Your ref: TR010025

**Application by Highways England for an Order Granting Development Consent for the A303 Amesbury to Berwick Down (Stonehenge) scheme**

**DEADLINE 3**

Drawing Title			
Figure 11.1: Site location and previous archaeological fieldwork			
Designed RM/RG	Drawn RM/RG	Checked	Approved
		Date 11/03/2019	
Internal Project No.			
WA reference: 117881			
Scale @ A3		Zone

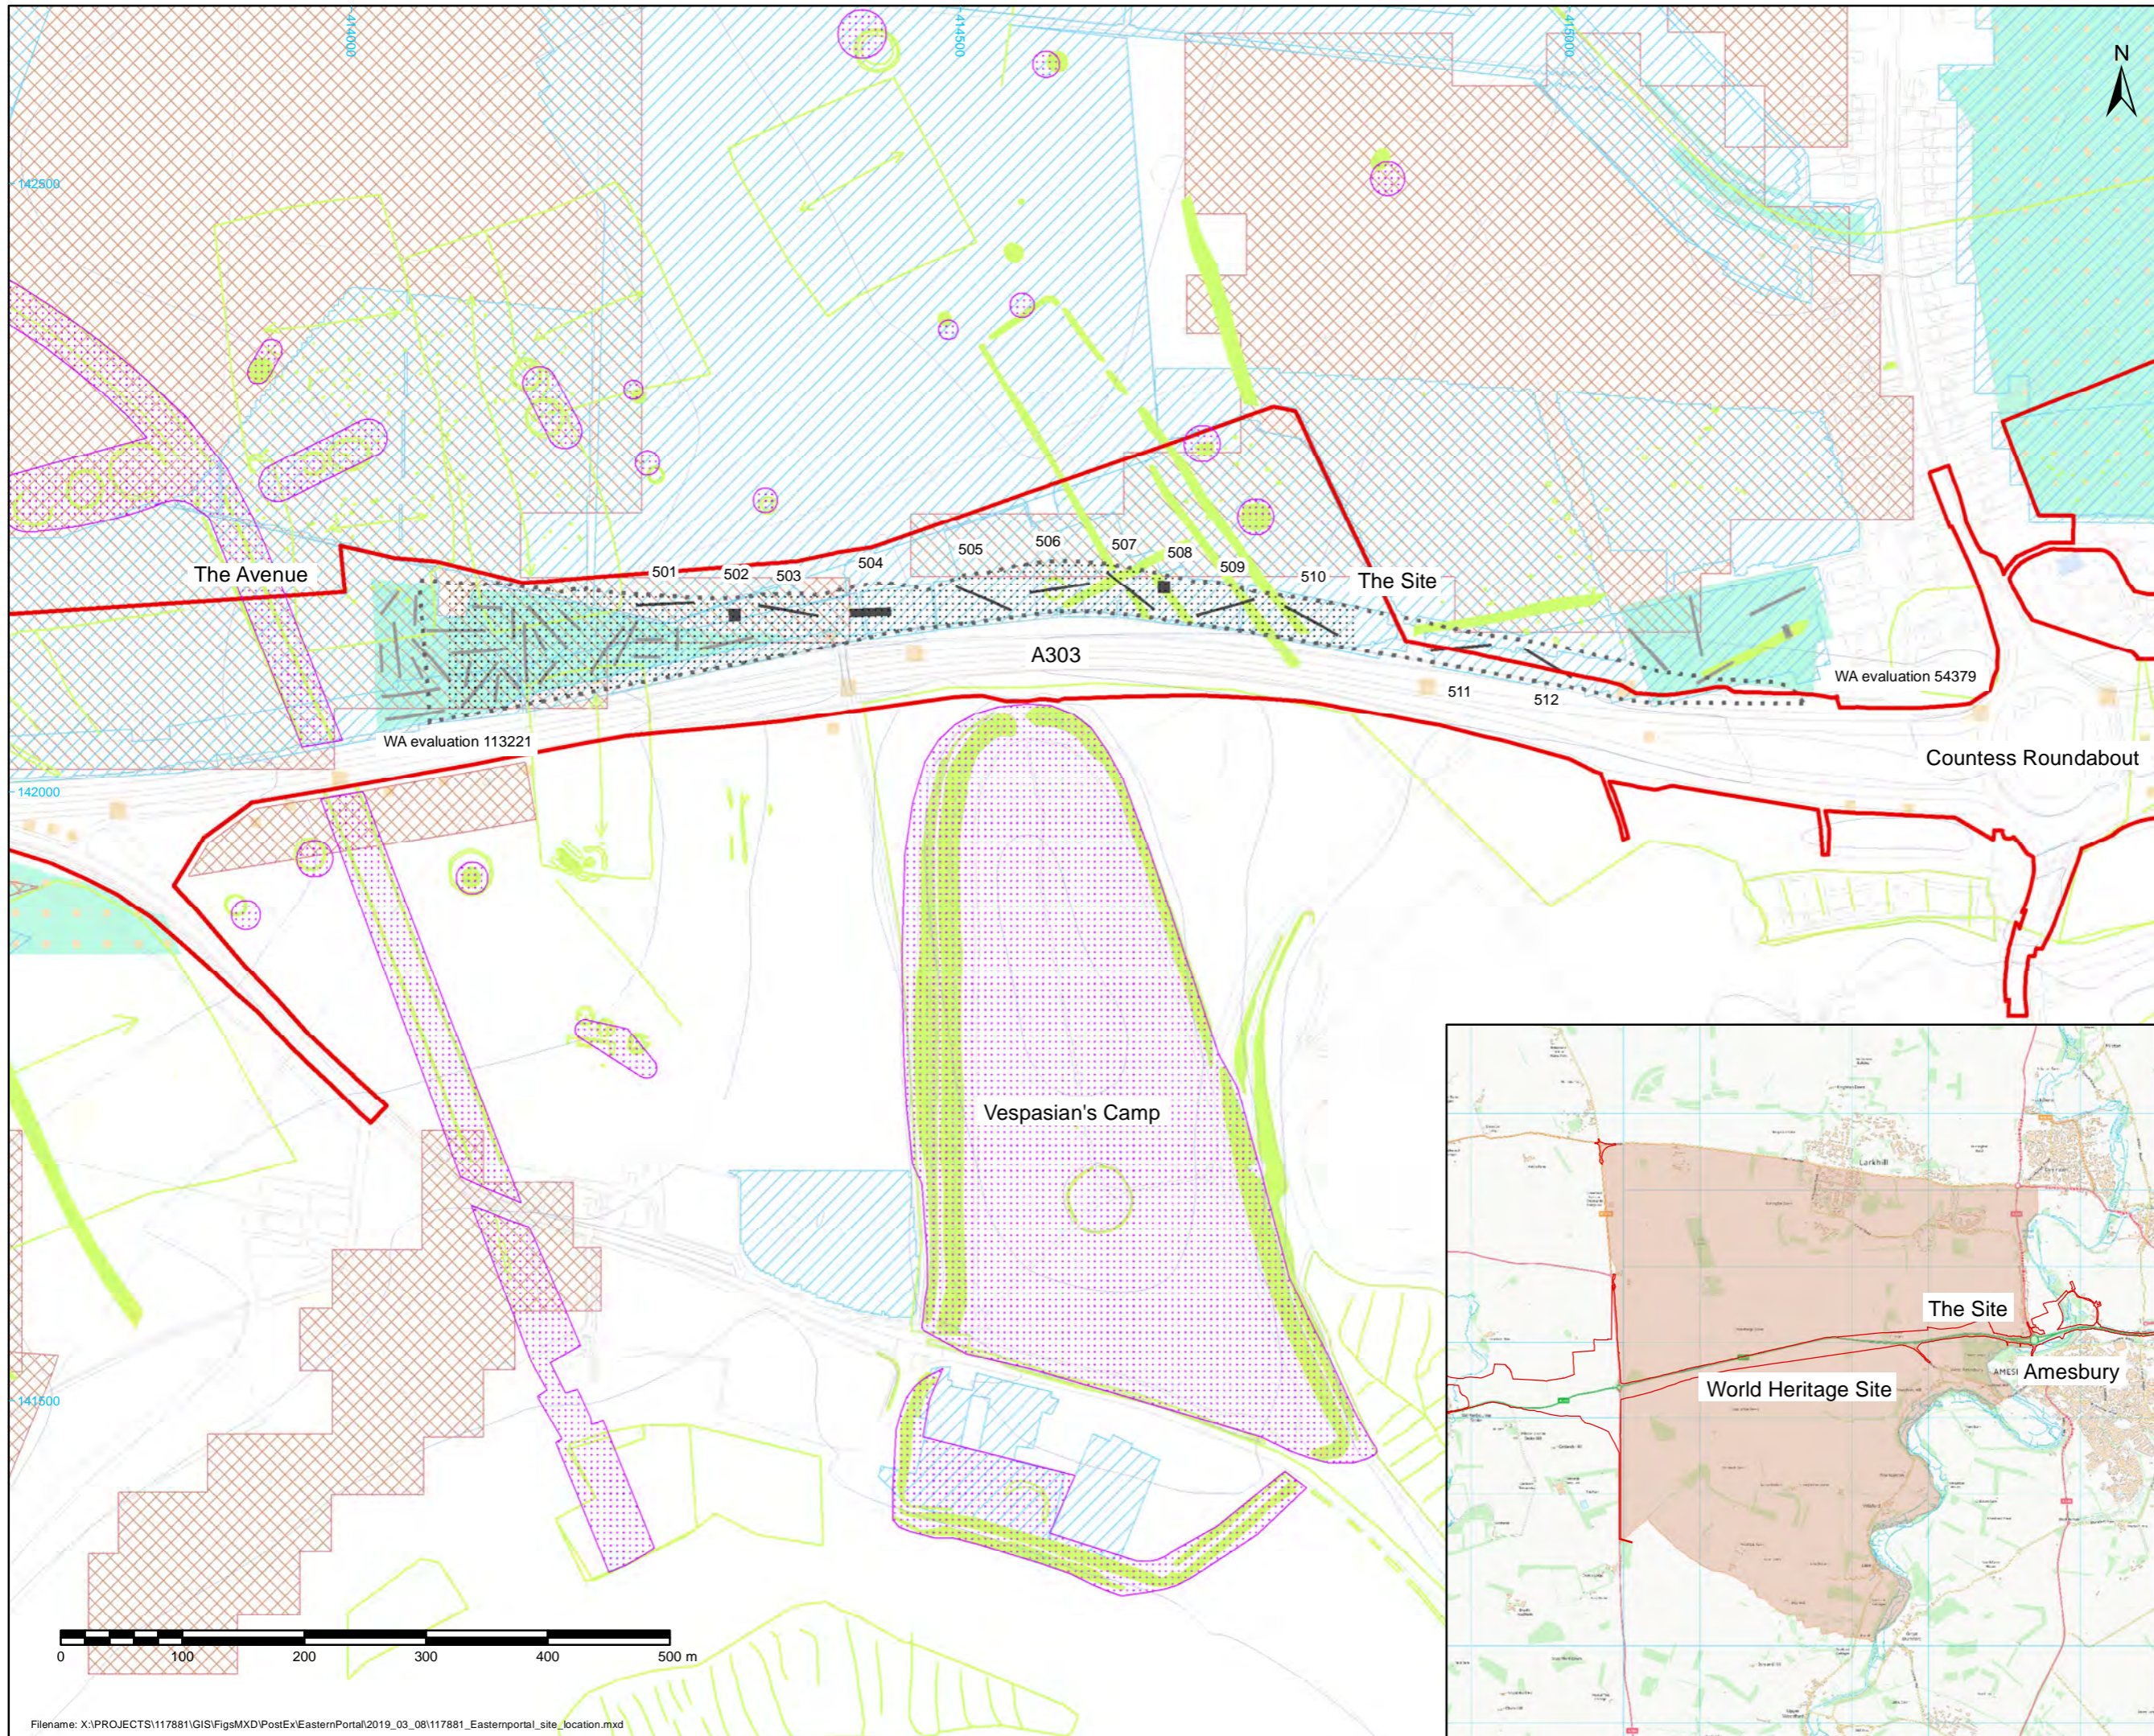
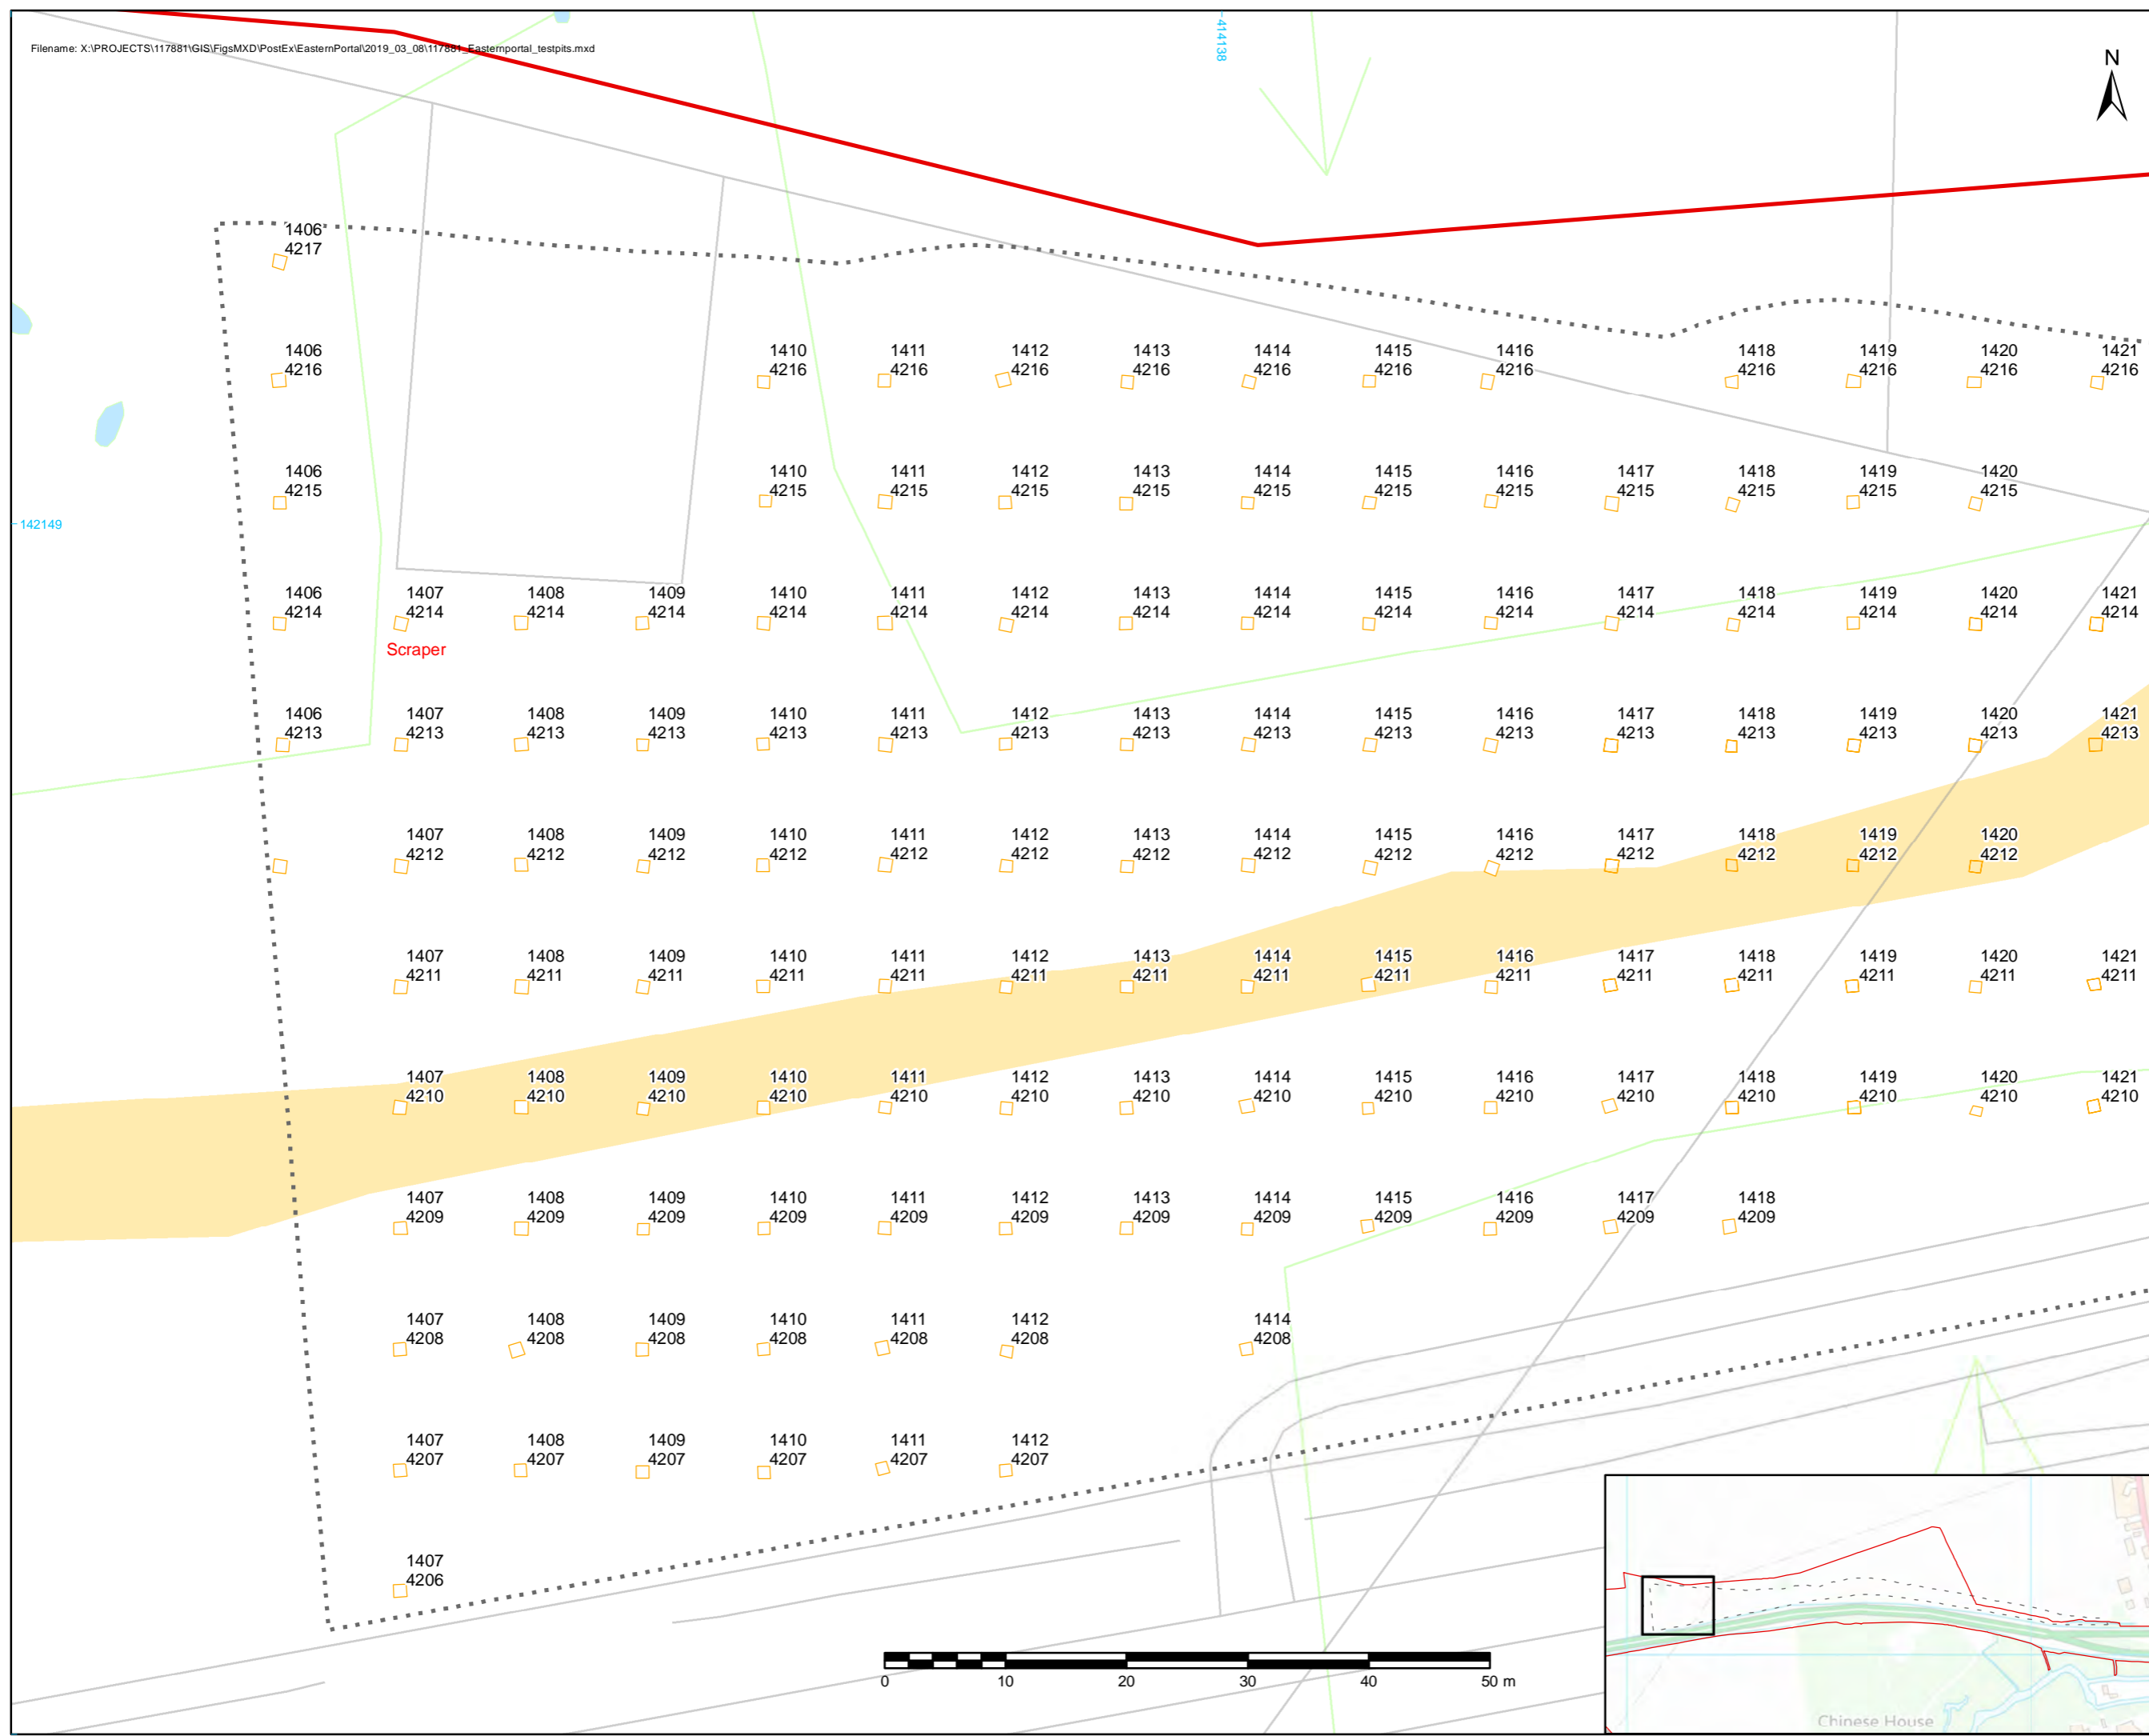
4.2.16 (page 48)	While paragraph 4.2.16 of the DAMS references diversions for water, power, fuel pipeline, and existing fibre optic cables, only the locations for power and fuel are shown in Figure 11.1. The proposed route corridor for water is shown on Figure 2.7 A-E of the ES, however no details of the proposed fibre optic corridor are show on either document. We ask for the applicant to submit a plan showing the proposed fibre optic cables corridor, as without this it is not possible to assess whether the proposed archaeological mitigation (Appendix E) is adequate or appropriate.
